LSC TRANSPORTATION CONSULTANTS, INC.
2504 East Pikes Peak Avenue, Suite 304
Colorado Springs, CO 80909
(719) 633-2868
FAX (719) 633-5430
E-mail: lsc@lsctrans.com
Website: <http://www.lsctrans.com>

New Breed Ranch
Filing No. 3
Transportation Memorandum
(LSC #S224230)
July 16, 2023

LSC Responses to EPC TIS Redline Comments

Figure 4  
**Directional Distribution**  
New Breed Ranch (LSC# S224230)

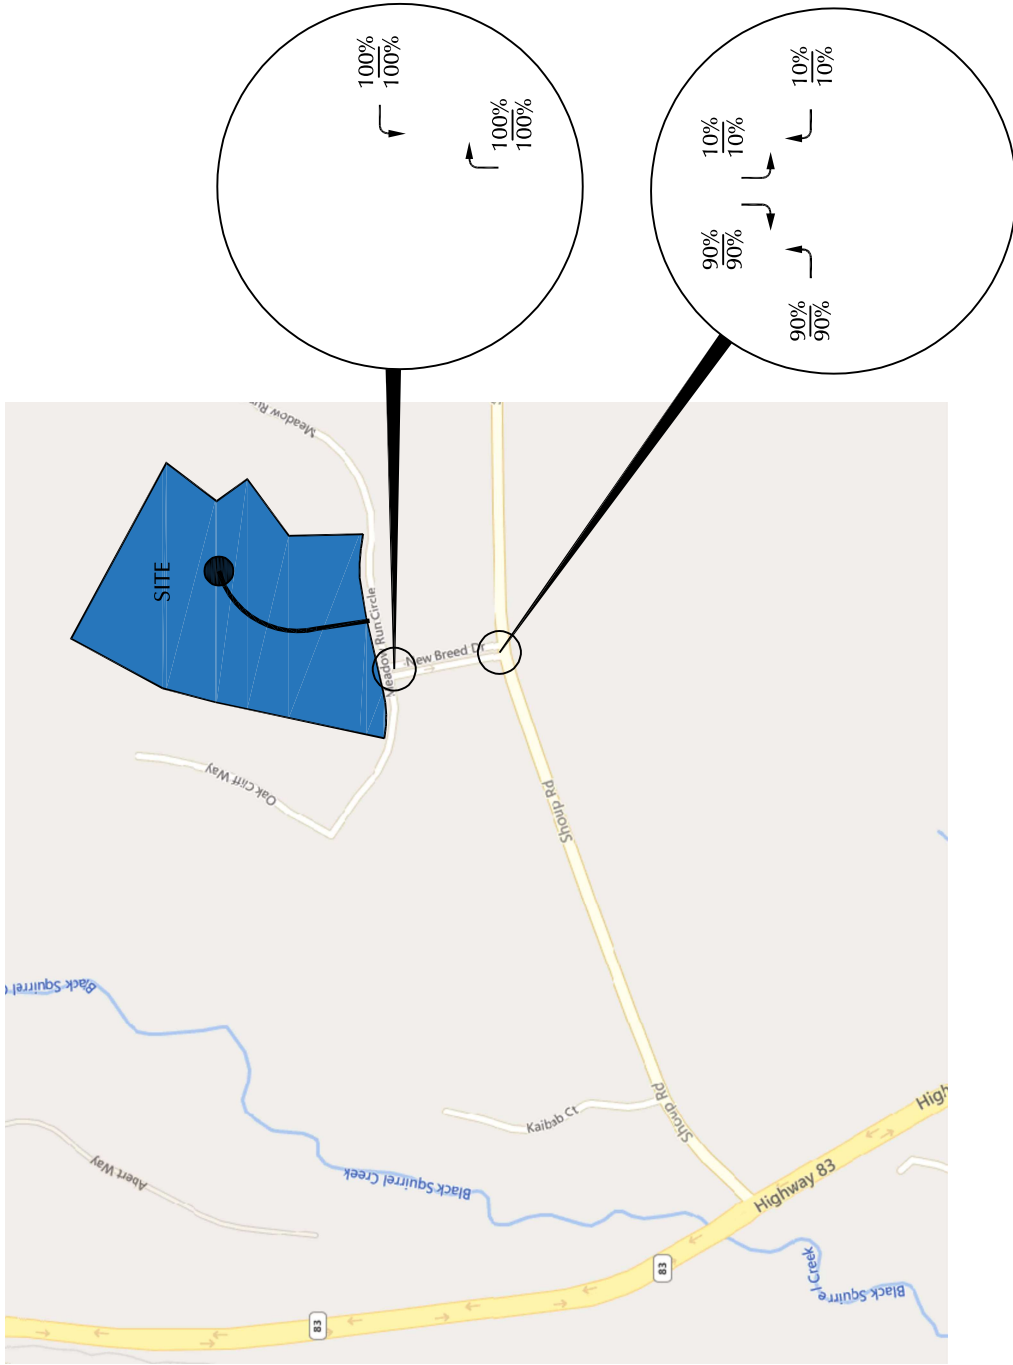
[Why there is no distribution on the left turn at this intersection?](#)

Author: jchodsdon Subject: Sticky Note Date: 9/25/2024 08:29:36
LSC Response: This has been corrected in the updated TIS.

Existing Pavement Markings Detail at the Shoup Rd/New Breed Dr Intersection

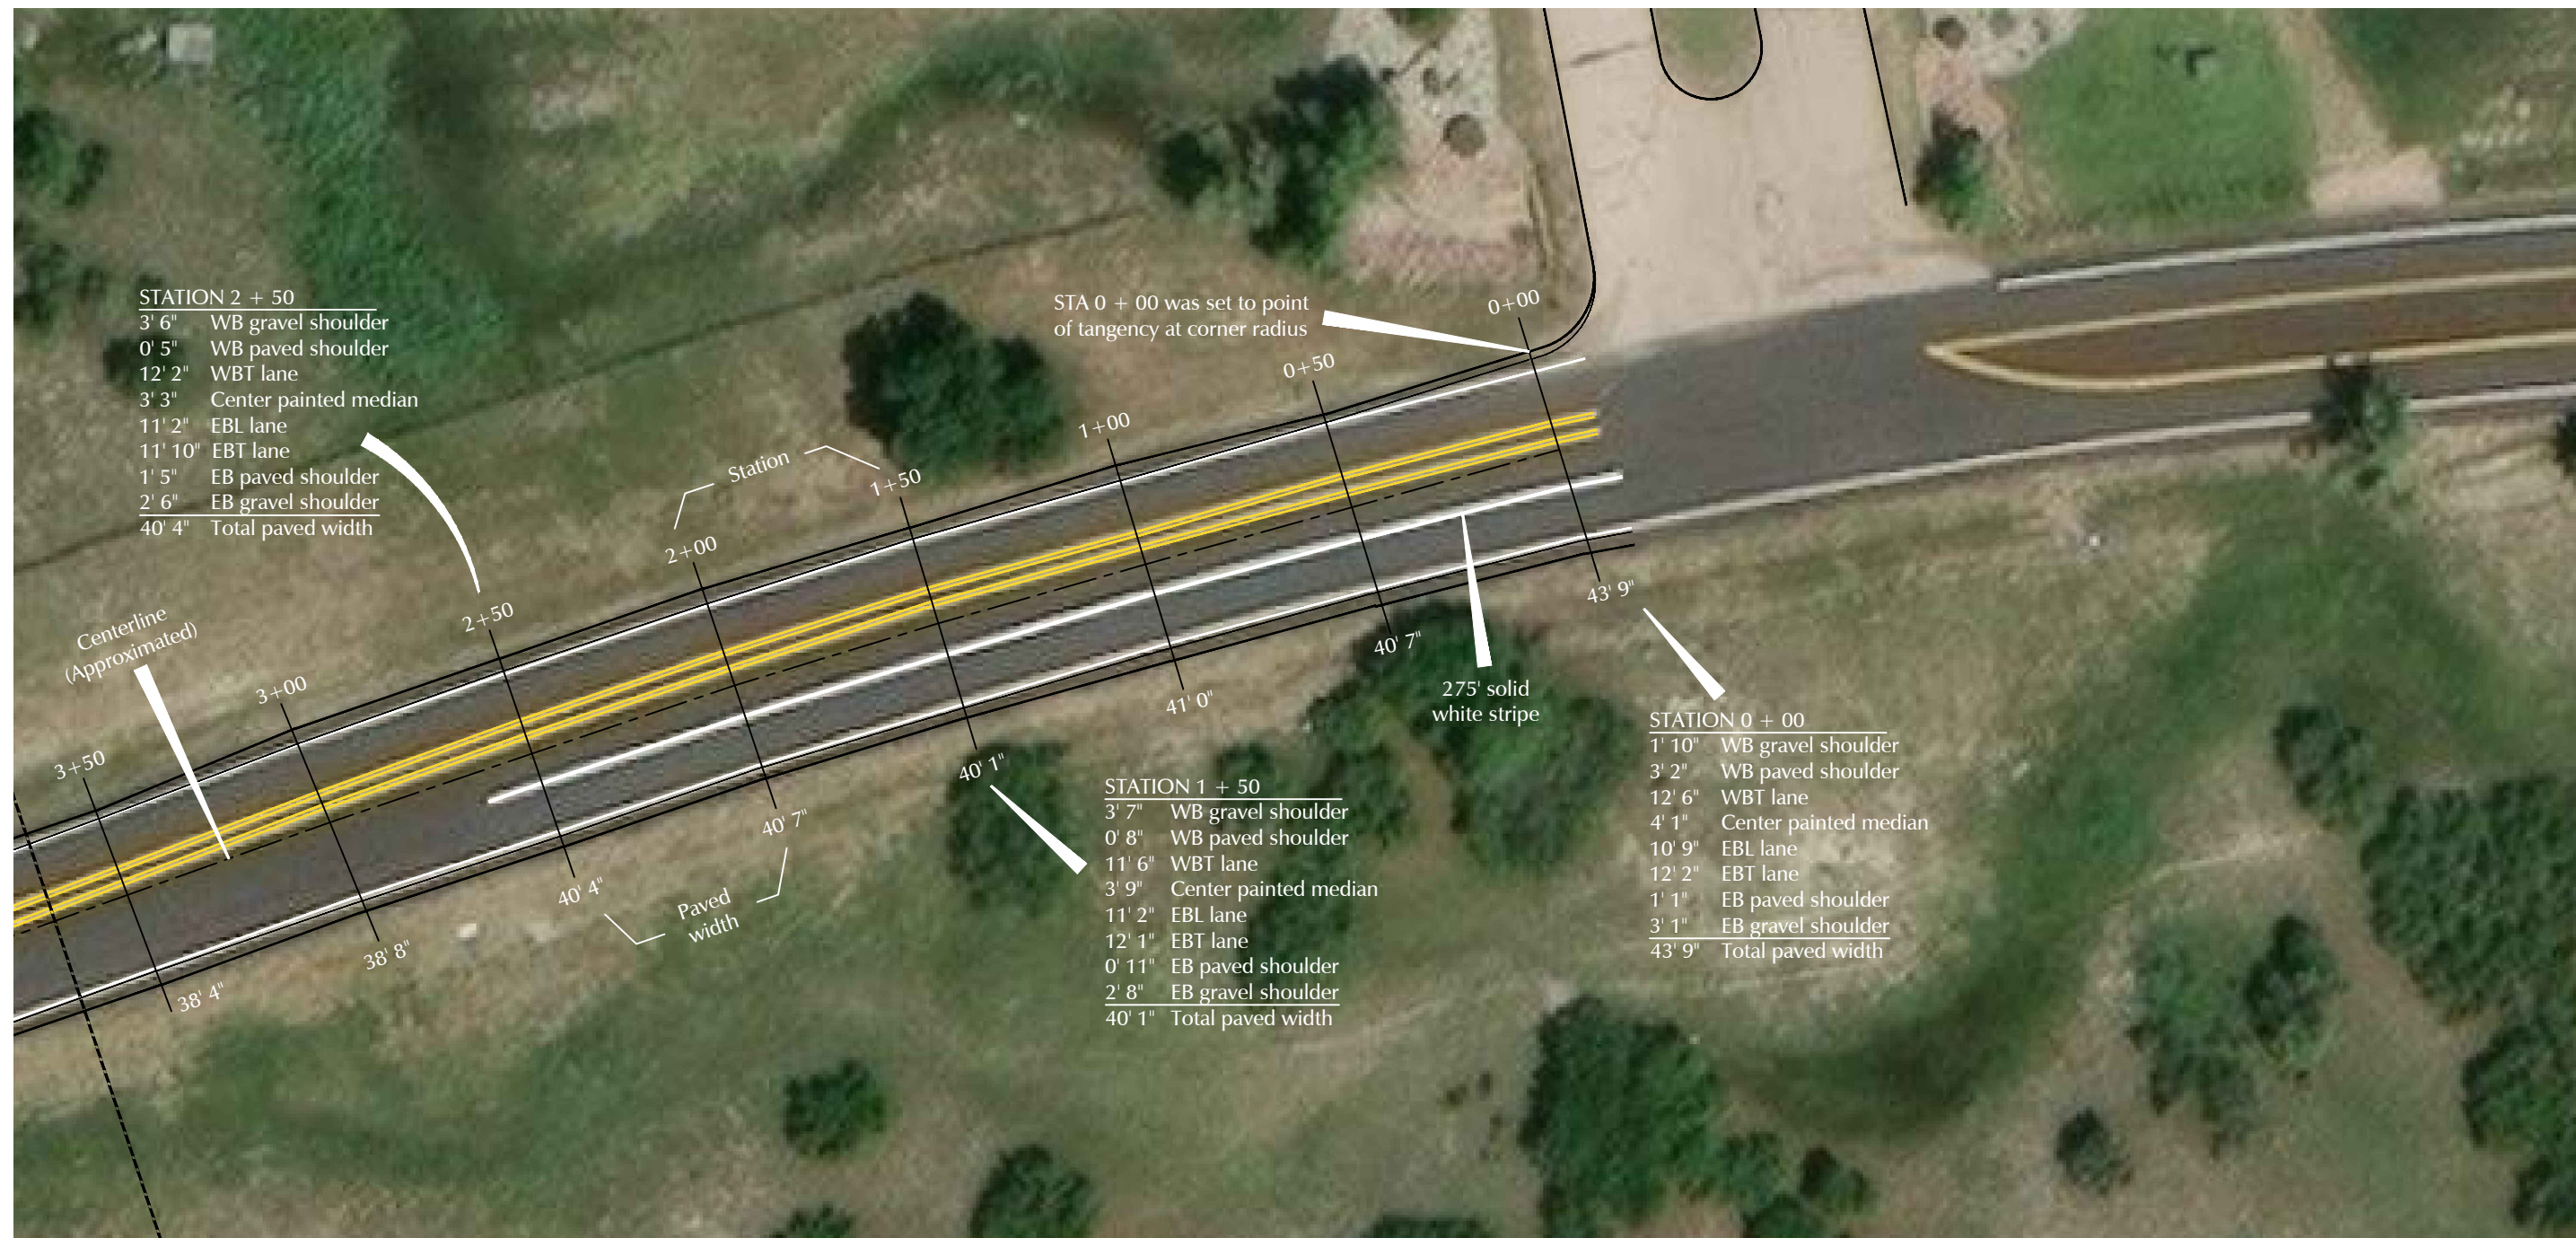
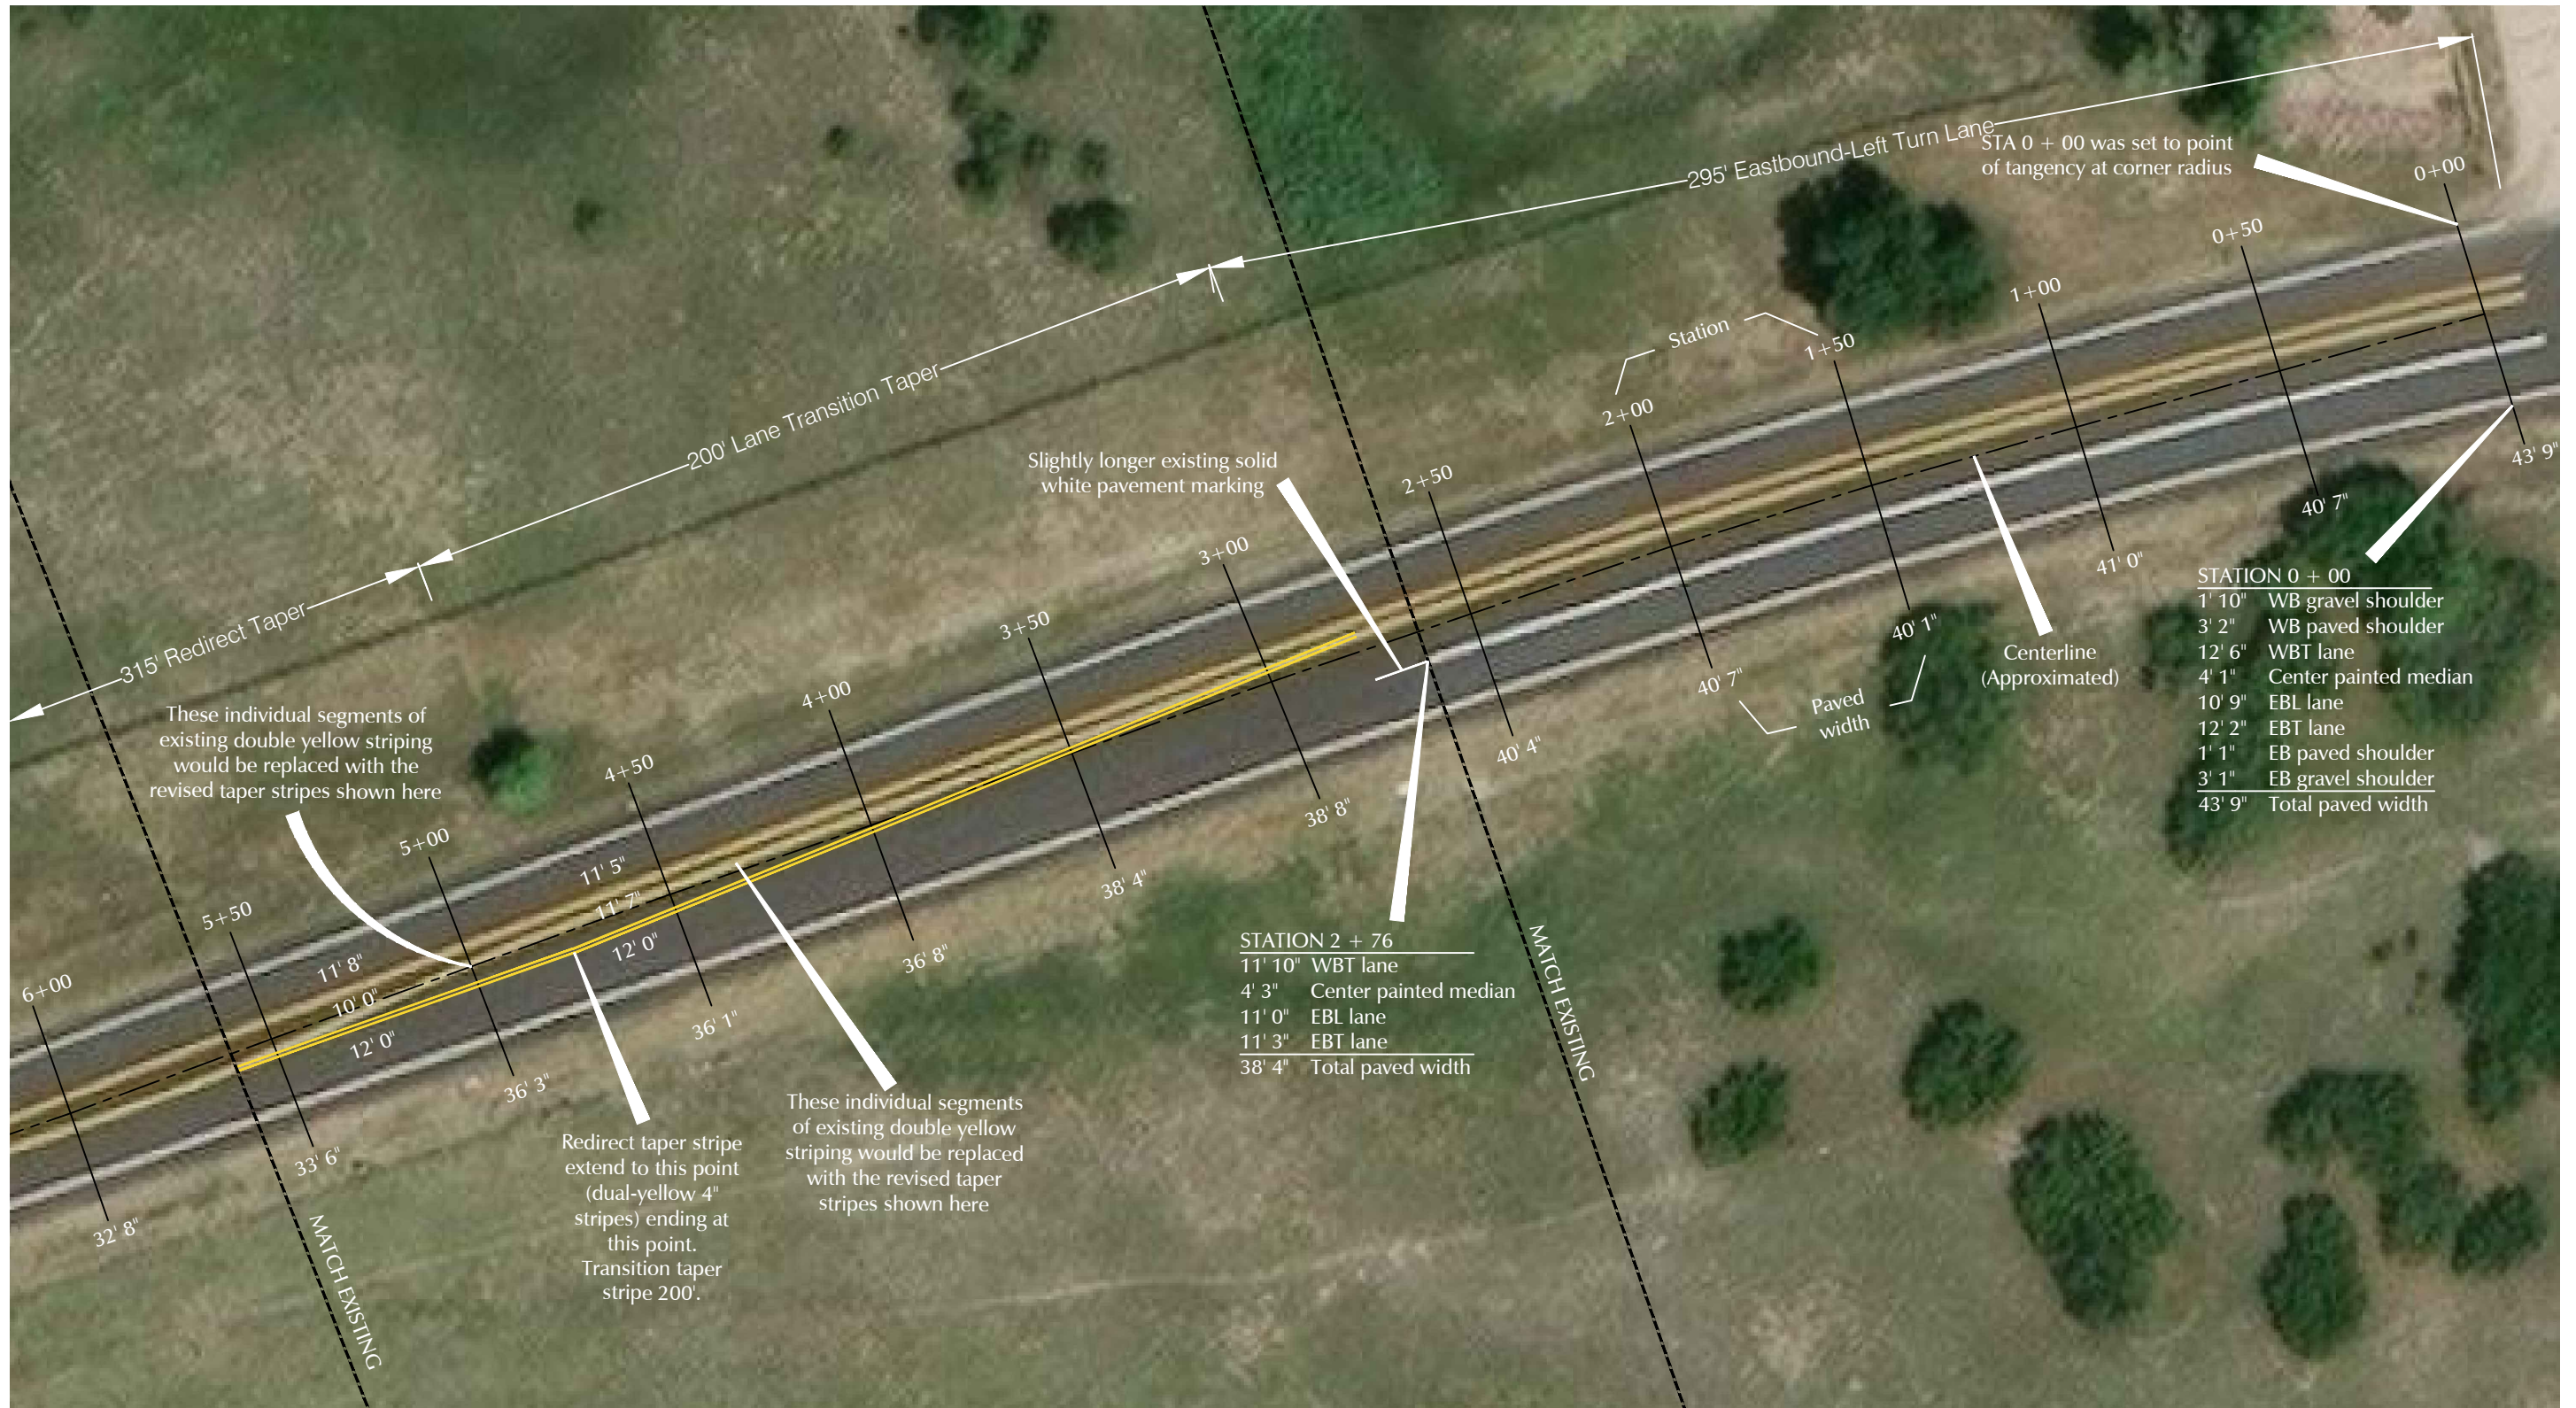
The existing turn lane does not appear to be striped for this length per GIS aerials. It appears that the striping may need to be lengthened.

Author: jchodsdon Subject: Sticky Note Date: 9/25/2024 08:29:47
LSC Response: This paragraph has been revised. Also please refer to the striping exhibits that have been added to the report. The striping does not require lengthening. This has been verified through field measurements and the striping exhibits. The lane, as striped in the field, has a shortened transition taper stripe and longer gap than normal. The current striping is not problematic, but LSC has prepared a striping exhibit for use at such time the County repaves and restripes Shoup or otherwise refreshes pavement markings with regular maintenance.
